Outline application with all matters reserved for the erection of 1 No. dwelling.
Land south of garage compound & East of 12 Alfriston Close Felpham

OBJECTION to FP/139/19

Land East of 12, Alfriston Close, Felpham, West Sussex, PO22 6QB

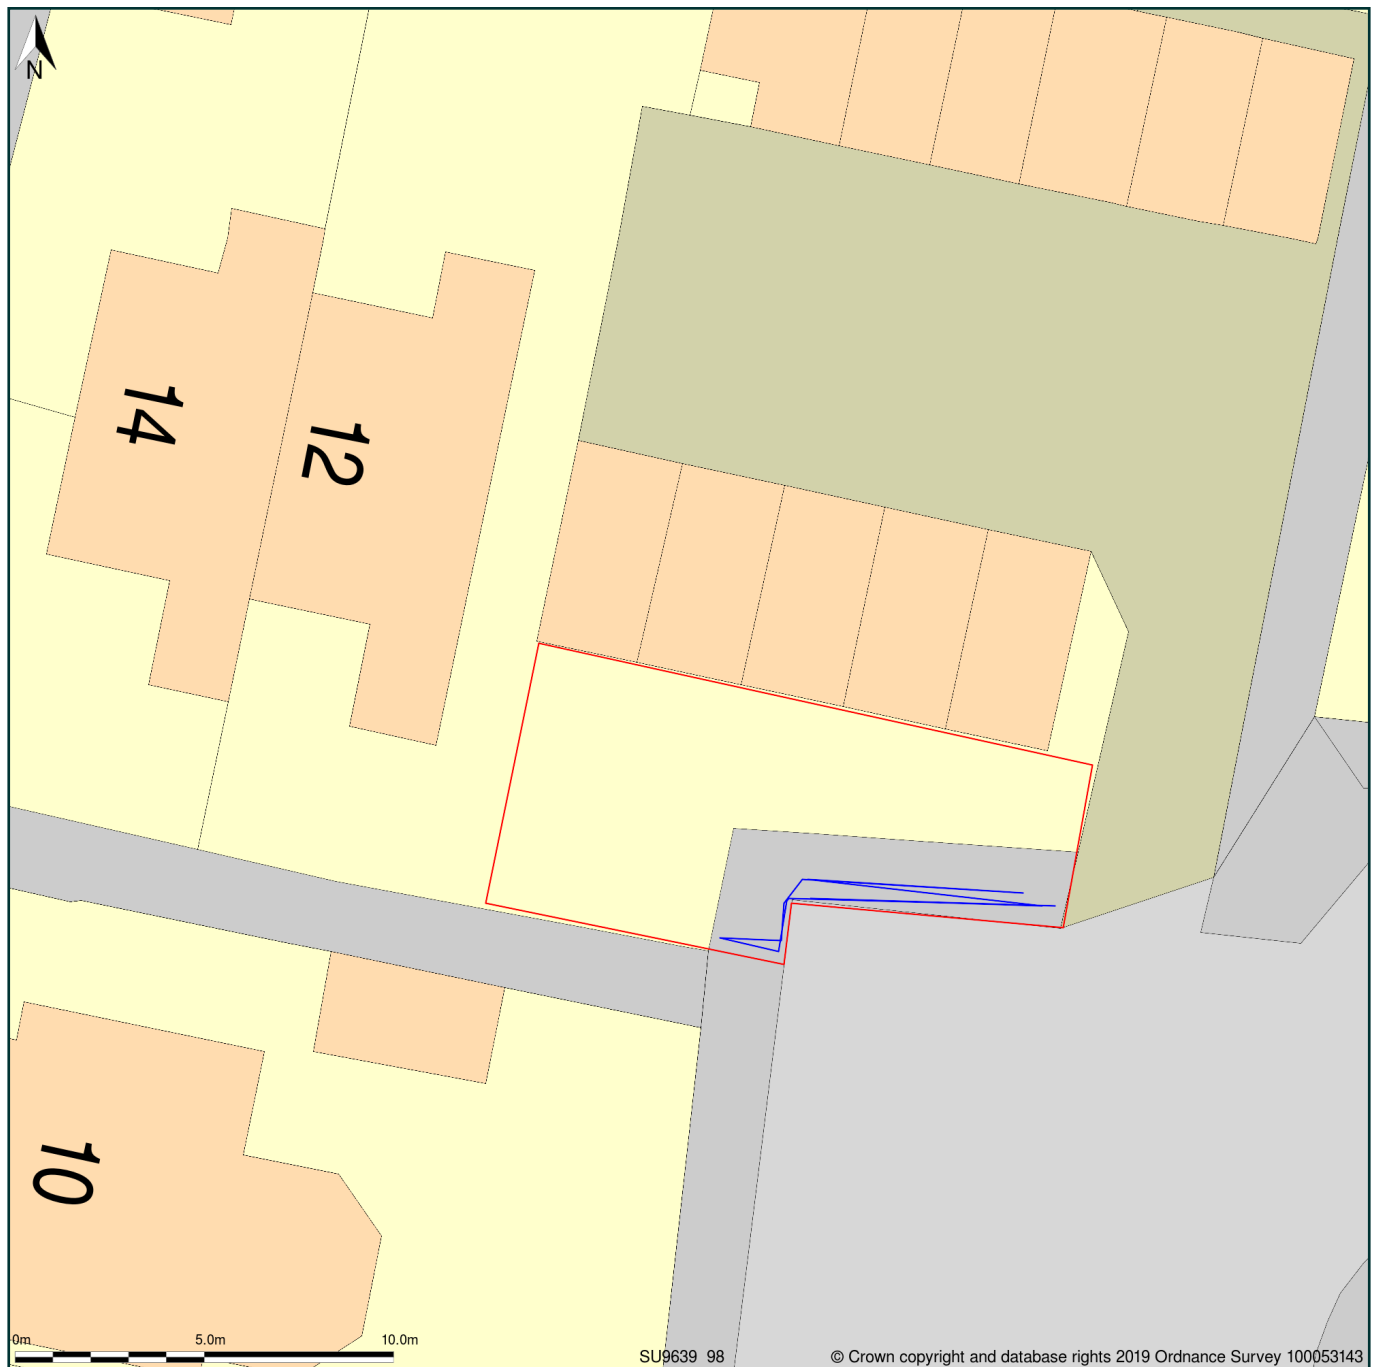
The block plan of the application shows that the current public footpath adjacent to the green space will be removed in favour of the property but with no consideration for pedestrians who will be forced to step into the road to cross to the pavement on the other side.

The planning application does not show the current position of the street lamp which sits on this green space and is invaluable to those who use the alleyways to access 12 and 14 Alfriston Close,

7 to 10 Fittleworth Drive, and the garage compound. As the public footpath is to be removed under this application there would be no logical place to relocate the street furniture.
